SUBMITTOR	MATTERS RAISED	REQUESTS / COMMENTS	APPLICANT RESPONSE
Agency			
NSW DPIE	Construction phase	Please provide a timeline for the construction of the development, including the breakdown of early works, construction and fit out.	Indicative target program: <ul style="list-style-type: none"> Demolition / site preparation works: July 2021 – September 2021 Construction (until tenant access date): October 2021 – October 2022 Fitout installation / Commissioning works: November 2022 – June / September 2023
	Customer pick up facility	Please detail the proposed operational hours for the customer pick up component of the development.	It is expected that the customer pick-up component of the development would operate mostly between 6am - 10pm. Notwithstanding, there may be occasional collection outside these hours.
		Please provide detail on the expected number of daily visitors to the customer pick up facility.	The drive through pick-up will have a service capacity of some 60 vehicles per hour, although the peak number of pick-ups will be limited to some 20 customers per hour. An operational management plan will be prepared for the customer pick-up facility. Pick-ups will be scheduled

**SSD-01**

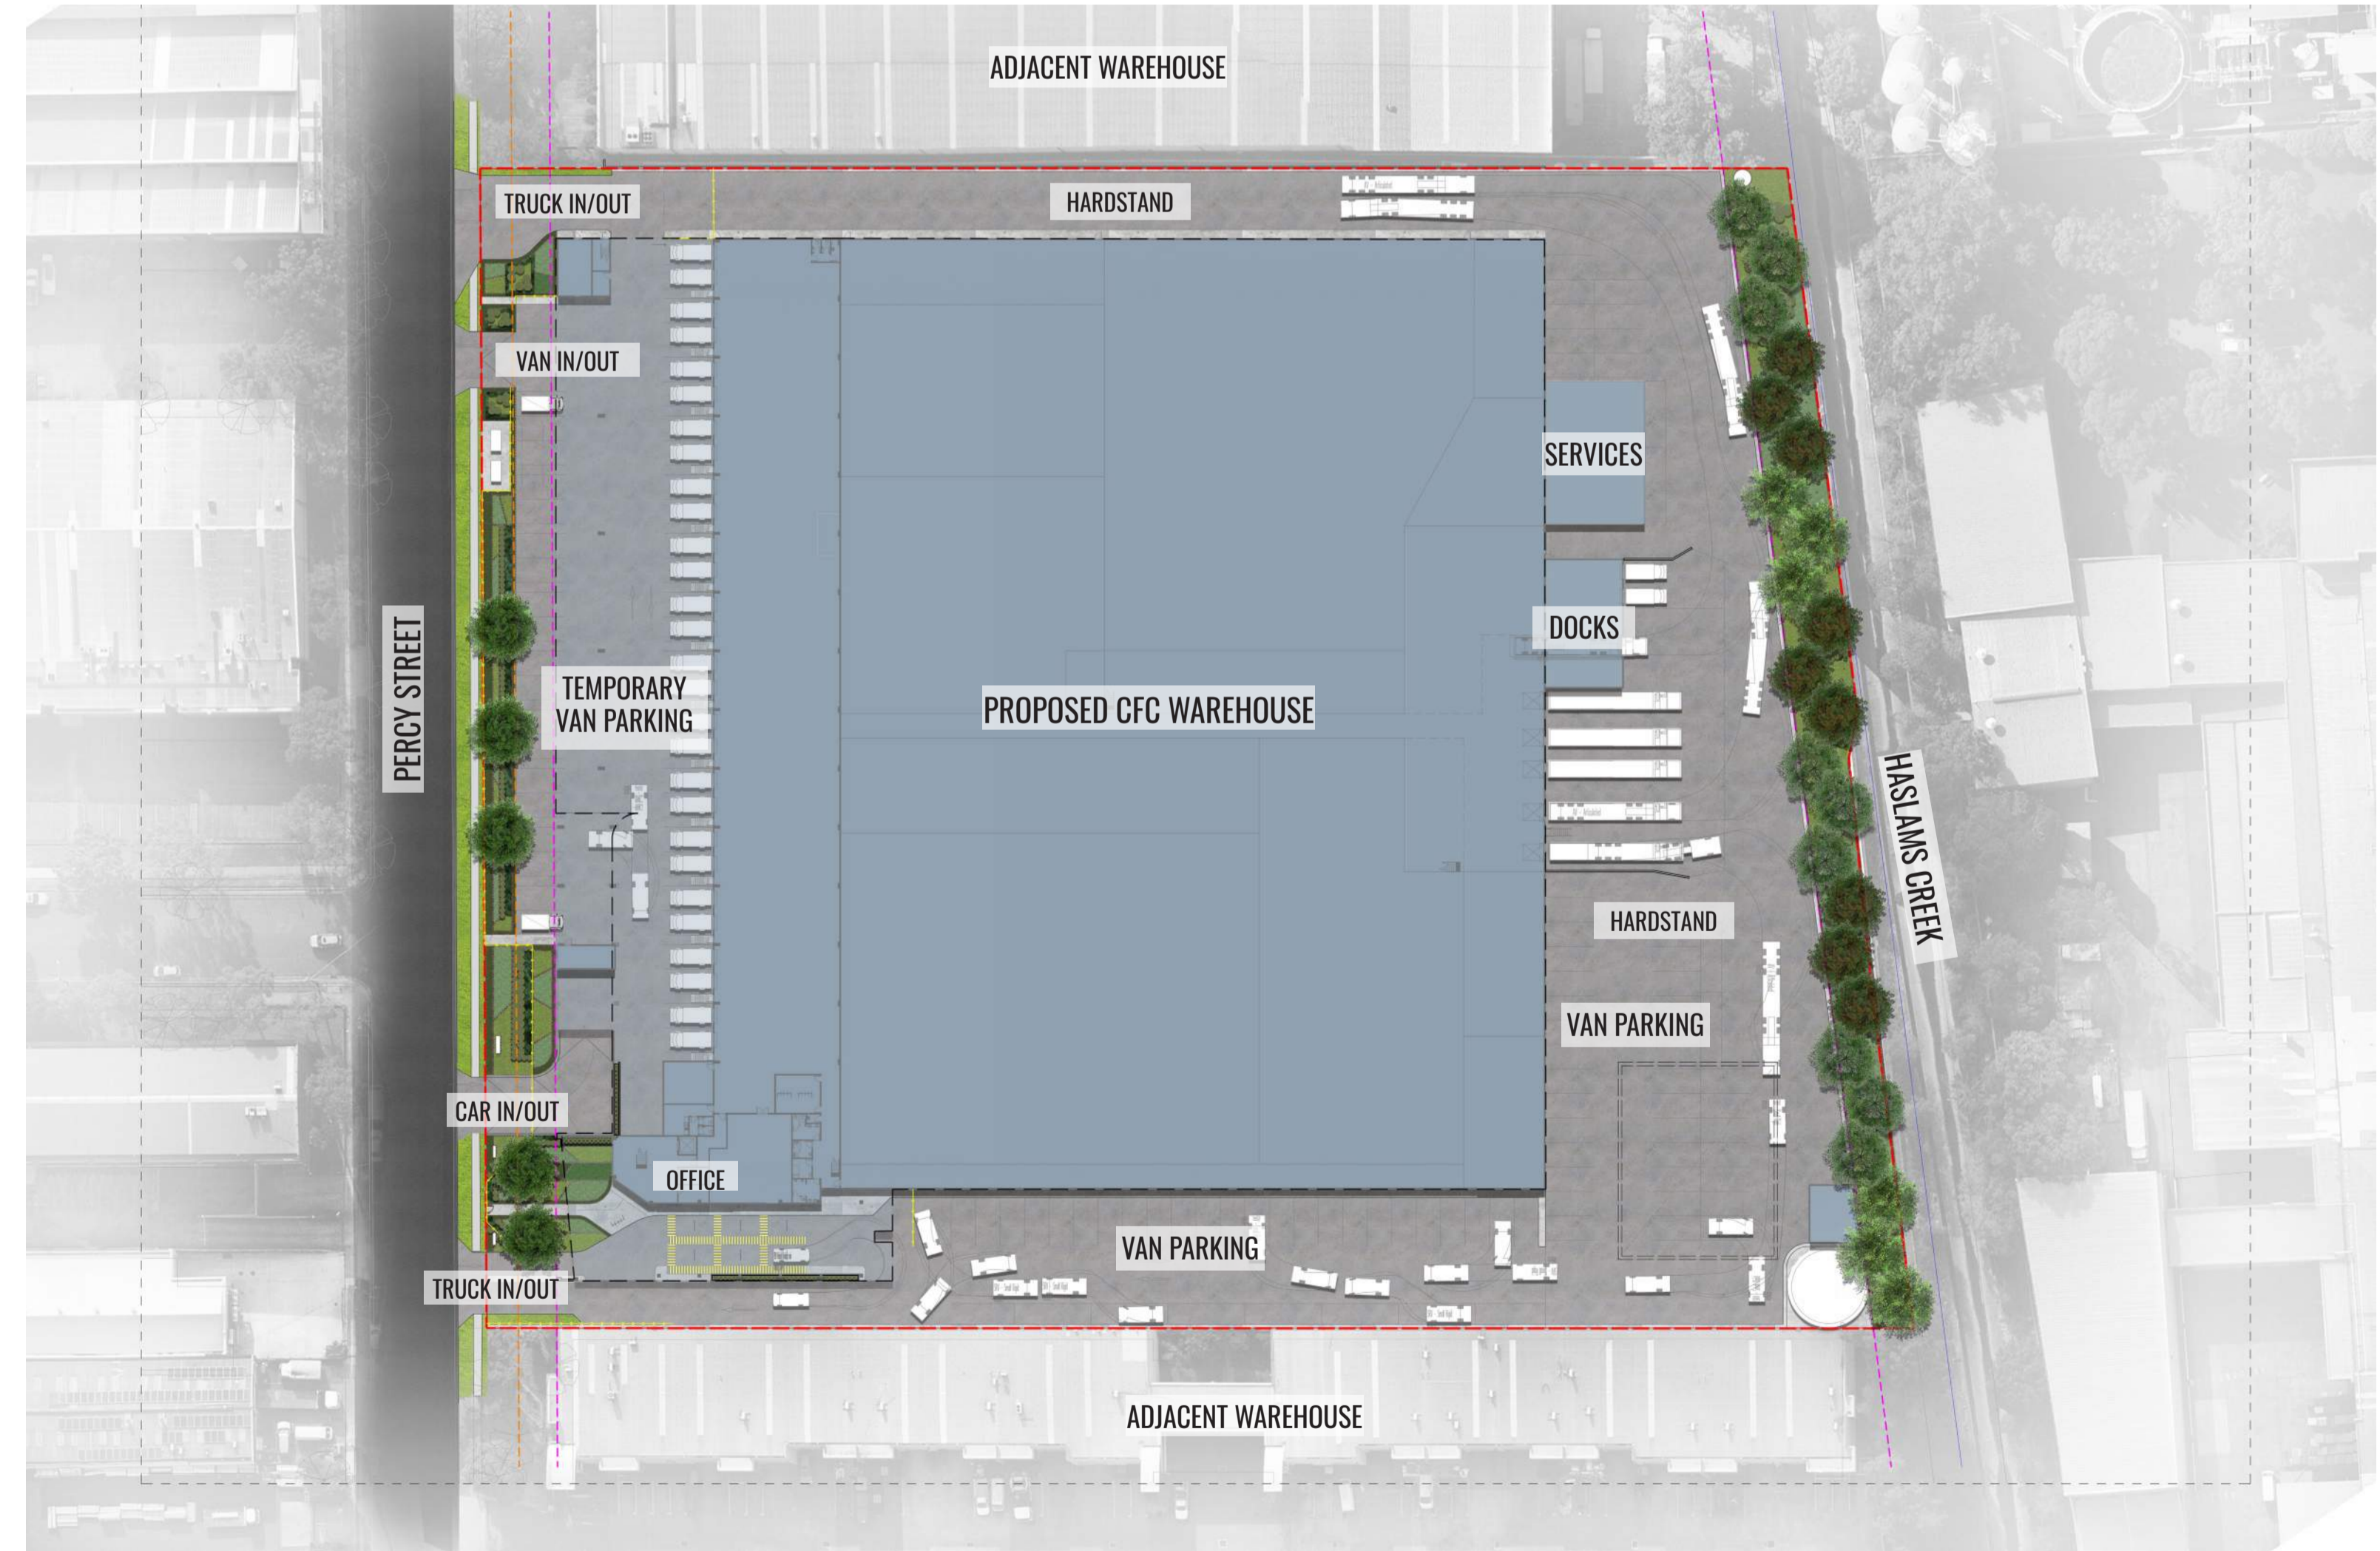
Landscaping (Industrial Areas DCP Chapter comments)	The ADCP2010 “Industrial Areas” chapter at Part 4.0 (Development Control D6) requires a minimum of 15% of an industrial site to be landscaped. The landscaping calculations submitted with the development application varies from 7.7% to 12.93% of the site between documents. Council’s own assessment identifies landscaping occupying 7.8% of the site which is equivalent to 2,527.2 square metres. A request is made to increase the amount of landscaping on site to achieve closer compliance with Part 4.0 (Development Control D6) of the ADCP2010 “Industrial Areas chapter”.	<p>The proposed development offers a total area of 2,430m² of complementary landscaping, which equates to 7.5% of the subject site. It is noted that this calculation does not account for any turfed areas below the proposed suspended slab. The land allocated to landscaping is generally in accordance with the extent of landscaping currently provide on site (pre redevelopment). The pre development landscaped area equates to approximately 7.65% of the site area (2,483m²).</p> <p>Whilst it is acknowledged that the ADCP2010 suggests that a minimum of 15% of an industrial site is to be landscaped, we note that the intent of development control plans is to ‘provide guidance’ to proponents and consent authorities in achieving land use zone objectives and facilitating permissible development under an environmental planning instrument.</p> <p>As is noted in Part 2, Clause 11 of the <i>State Environmental Planning Policy (State and Regional Development) 2011</i>, which governs this SSD Application:</p> <p><i>Development control plans (whether made before or after the commencement of this Policy) do not apply to:</i></p> <p>(a) <i>State Significant Development</i></p> <p>As such, it is respectfully submitted that it is pertinent to acknowledge the status and application of the ADCP2010 in the consideration of this SSD Application, however, should not be relied upon for strict compliance.</p> <p>To complement the proposed development, native species will be planted in a 4.5m wide landscape area immediately adjacent to the site boundary. This will be most effective to street level views and assist in softening the development. To the rear along Haslams Creek a 10m landscape strip runs adjacent to the eastern site boundary. This landscape buffer allows for large endemic canopy tree planting, smaller sub-canopy evergreen trees, shrubs and groundcovers, allowing a layered screening approach with trees ranging in heights from 7-20m+ and shrubs 1-5m, which will partially screen the development from potential visual receivers.</p> <p>This landscaping provision is considered to accord with the surrounding area and:</p> <ul style="list-style-type: none"> ▪ forms an integral part of the overall design concept, ▪ softens the impact of buildings and car parking areas, ▪ provides for passive/recreational use of workers of industrial areas, ▪ reinforces the architectural character of the street and positively contributes to maintaining a consistent and memorable character. <p>An analysis of the surrounding locality and areas attributed to landscaping has been undertaken to demonstrate that the proposed development is generally consistent with the surrounding amenity.</p>

SUBMITTOR	MATTERS RAISED	REQUESTS / COMMENTS	APPLICANT RESPONSE
Agency			<p>Landscaping adjacent to the subject site, on properties fronting Percy Street and Haslams Creek, range from approximately 3% to 16% of their relative site areas.</p> 
	Landscape comments (Tree replacement)	<p>It is recommended that the <i>Glochidion ferdinandii</i> and <i>Waterhousia floribunda</i> be replaced with <i>Melaleuca Styphellioides</i> and <i>Melaleuca linarifolia</i> or <i>Cupaniopsis anacardioidies</i>. The species are more suitable for the soil and proposed location given that heavy clay soils will be encountered. Where there is insufficient suitable soil for plants, shrubs, hedges, groundcovers and grasses onsite, consideration should be given to soil strata cells to allow for sufficient root growth and to reduce the likelihood of the clashing with infrastructure and assets.</p>	<p>Species selections have been revised in accordance with this item, as demonstrated in the revised Landscape Plans, prepared by Geoscapes Landscape Architects, which form part of Attachment D of this RTS.</p>

Drawing Title:  
**Tree Retention & Removal Plan**  
 DWG No:  
**SSD-07**

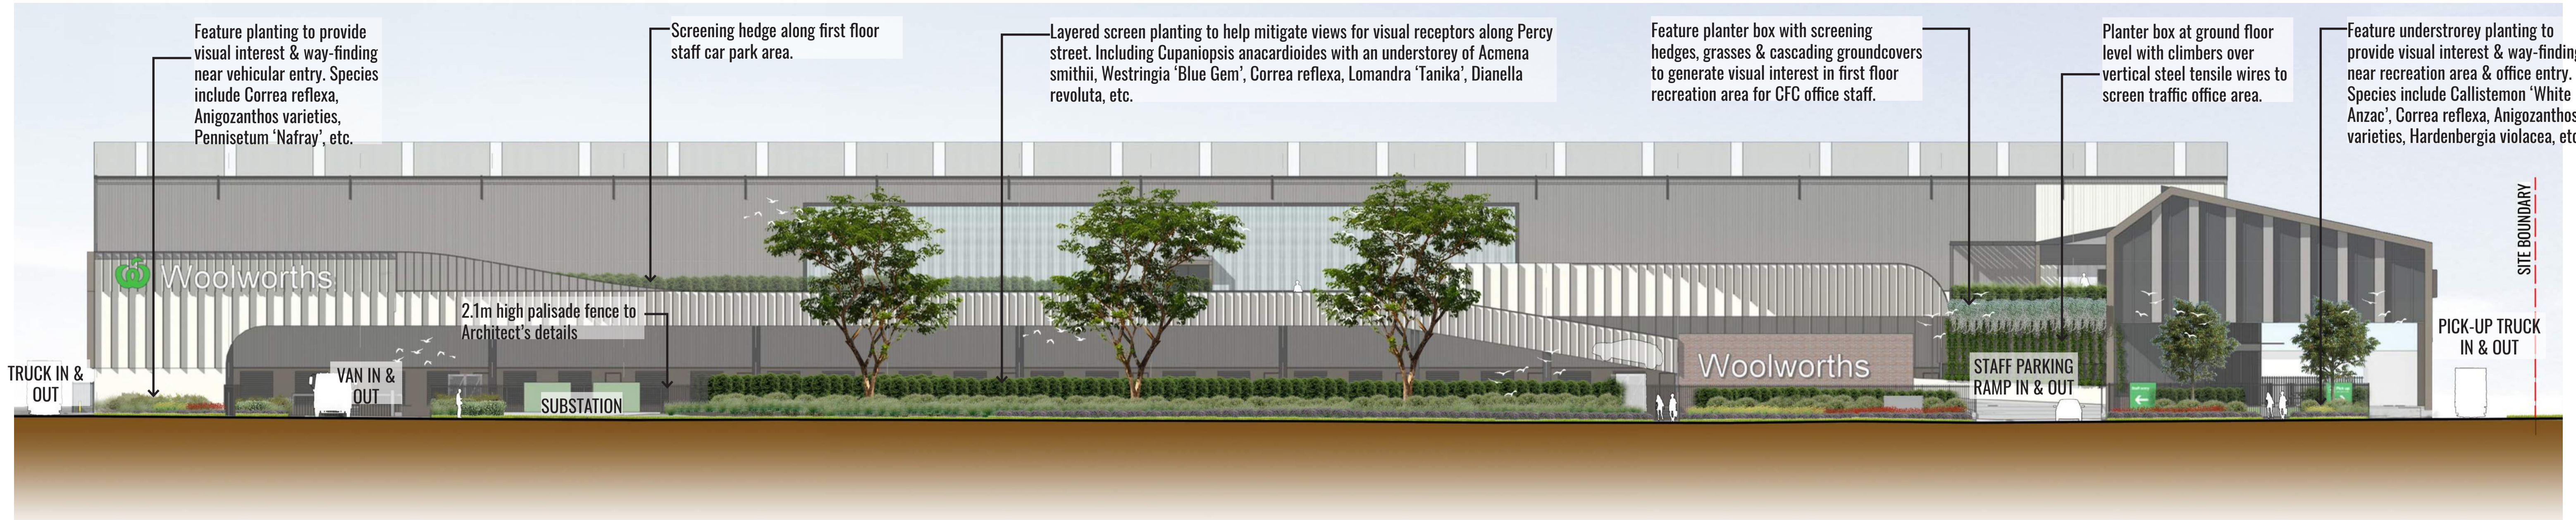
SUBMITTOR	MATTERS RAISED	REQUESTS / COMMENTS	APPLICANT RESPONSE
Agency			
	Tree Protection	As per the Arboricultural Impact Assessment, the remaining trees should be protected under AS4970 - Protection of Trees on Development for the entirety of the proposed development. As per AS4970, a project arborist should be appointed prior to the beginning of construction to ensure the conditions of tree protection are adhered too and should be present during pivotal stages of the development. As per the AIA, root investigation should be carried out prior to excavation and in conjunction with project arborist.	Noted – no action required.
	Flooding	An updated flood advice letter shall be obtained from Council as the flood advice letter is valid for only months.	An updated flood advice letter has been obtained from Council.
		The subject development shall comply with Chapter 6 of 'Auburn Development Control Plans 2010 – Stormwater Drainage'. In this regard, the flood report shall address all the controls nominated in Table 5 Auburn Development Control Plan 2010 - Stormwater Drainage.	Additional information has been provided in the addendum Flood Report, included in Attachment G of this RTS.

Project
**PROPOSED WAREHOUSE DARK STORE
11-13 PERCY STREET, AUBURN NSW**
Title
OSD TANK PLAN, SECTIONS AND DETAILS

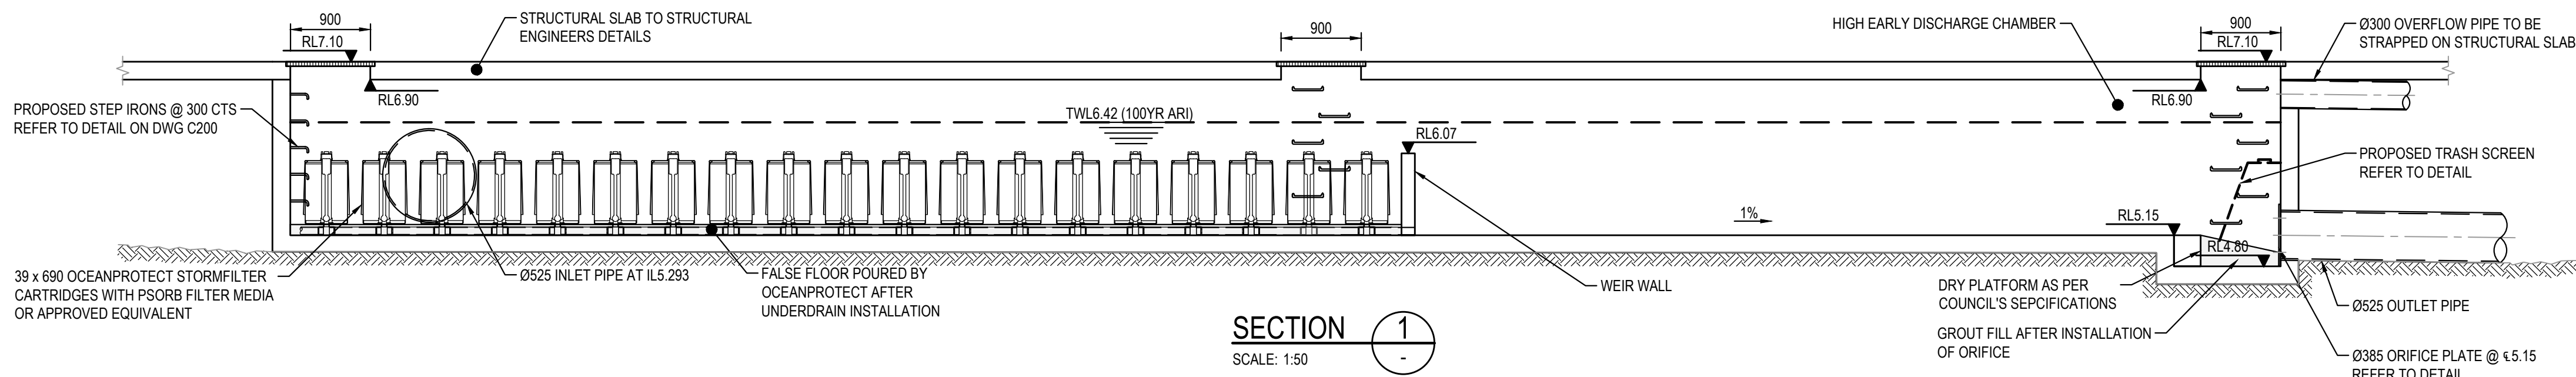
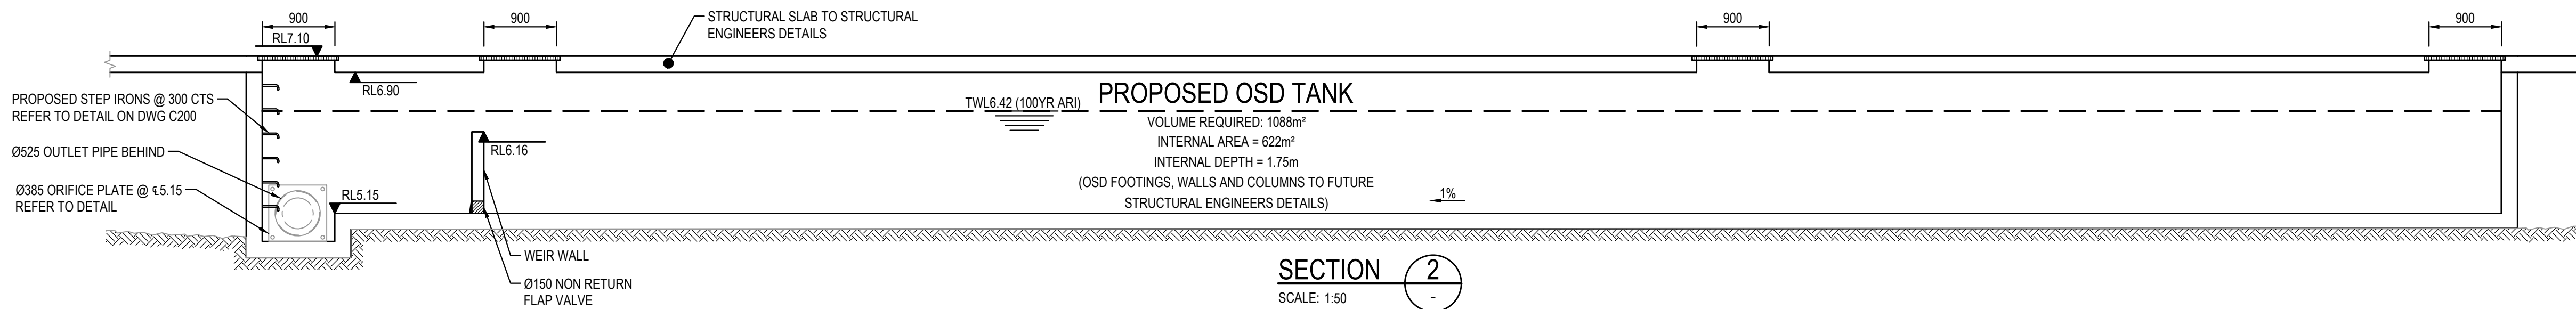
The proposed OSD tank is located below the 1% AEP flood and will not perform as per the submitted OSD calculation. The design shall be reviewed.	The proposed OSD has been moved toward the rear of the site, to drain to Haslams Creek.
		Stormwater shall be discharged to Haslam Creek subject to Sydney Water approval. Stormwater disposal to Percy Street is not acceptable. Percy Street frontage is affected by 1% AEP flood as per the survey and the ground level car parking spaces are located below the flood level.	The car park should be located above 1:20 year ARI plus freeboard. Henry & Hymas do not expect any flooding from Percy Street in 1:20 year ARI. The flooding along Percy Street in 1:100 year ARI is caused by the existing stormwater infrastructure and the existing pipe that connects with Haslams Creek. The proposed redevelopment and existing levels also have levels along the front boundary that ensure no spilling will occur from the road into the subject site. Since the spilling of flood water is prevented in the largest storm (1:100), it is assumed that there will be no risk of flooding even for smaller events such as 1:20 year ARI. The existing development at 11 Percy Street, currently discharges the stormwater to Percy Street, through 1 x 400mm pipe and few 225 pipes. That is approximately 1.1 ha that will be discharged from the OSD to Haslams Creek, which will significantly improve the flood situation along Percy Street.
